Our ref: NO/2025/116805/01-L01
Your ref: 3/2022/0317
Date: 27 May 2025

**RESERVED MATTERS APPLICATION IN RESPECT OF PHASE 5 AND 6 TO
INCLUDE ACCESS, APPEARANCE, LANDSCAPING, LAYOUT AND SCALE WITH
RESPECT TO 265 DWELLINGS FOLLOWING OUTLINE APPROVAL 3/2015/0895.
LAND AT HIGHER STANDEN FARM AND PART LITTLEMOOR FARM, CLITHEROE**

Environment Agency position

Detailed Landscape Proposals
Sheet 4
Standen, Phase 5 & 6

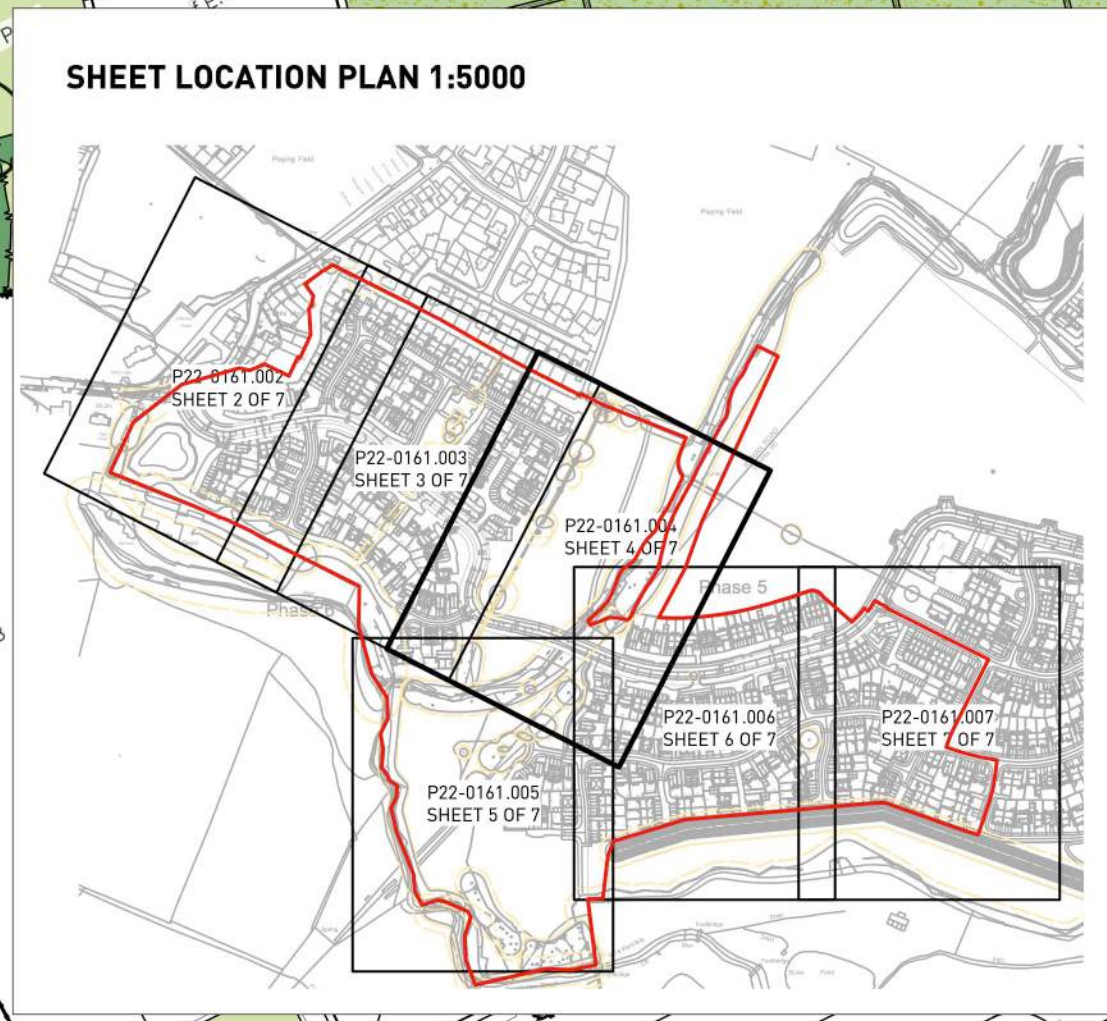
We are satisfied that drawing no. P22-0161,004, titled Detailed Landscape Proposals Sheet 4, dated 12/05/2025, attached to this application, demonstrates that a suitable protective vegetated buffer will be left between the development and adjacent water courses.
